**The Northampton Gateway Rail Freight Interchange Order 201X
Applicant's Response to s.55 checklist: minor errors and omissions**

INSET (E) A508 Grafton Regis

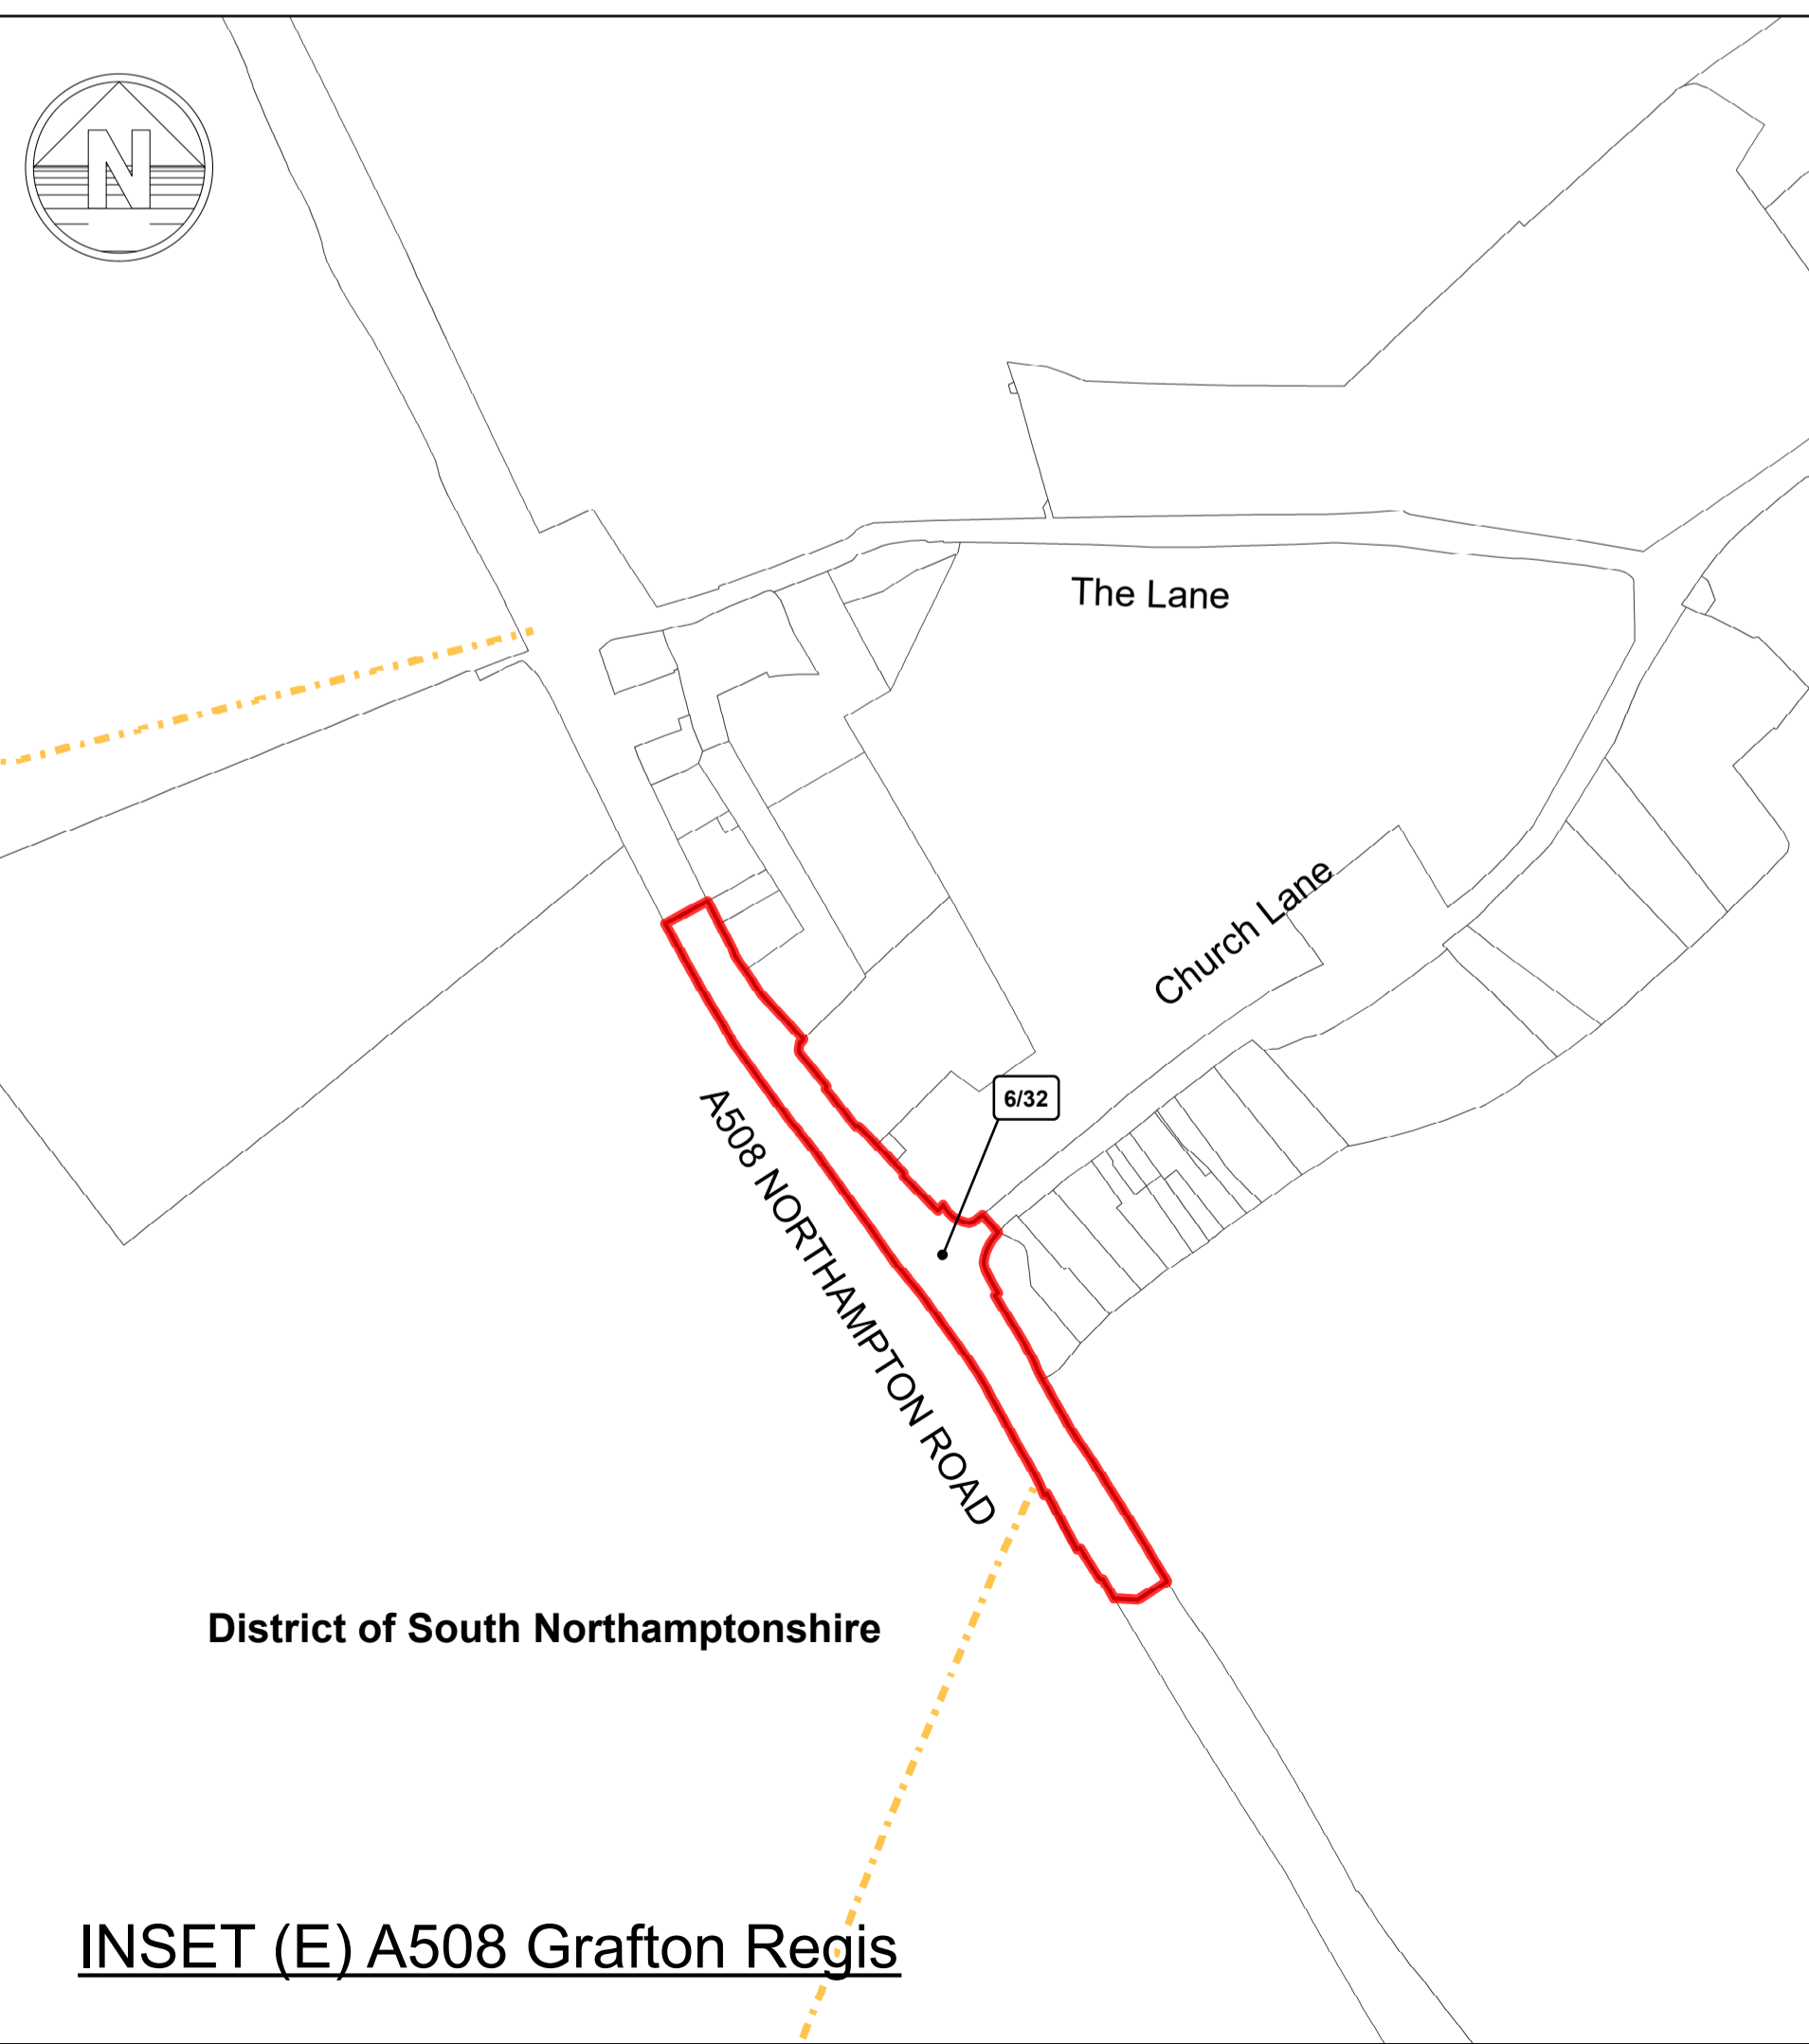
| 30. Are there any observations in respect of the documents provided above? | |
|---|---|
| <p>Land Plans (Doc 2.1A – 2.1F) The following plots on the land plans cannot be seen clearly: 2/29, 6/8, 6/12, 6/15 & 6/16.</p> <p>On Sheet 6 of the Land Plans (Doc 2.1F) the point at which plots 6/5, 6/6, 6/8 & 6/9 meet is unclear.</p> | Updated sheets 2 and 6 (Documents 2.1B and 2.1F) have been prepared with further insets to clarify these small parcels, together with an updated Key Plan (Document 2.1). |
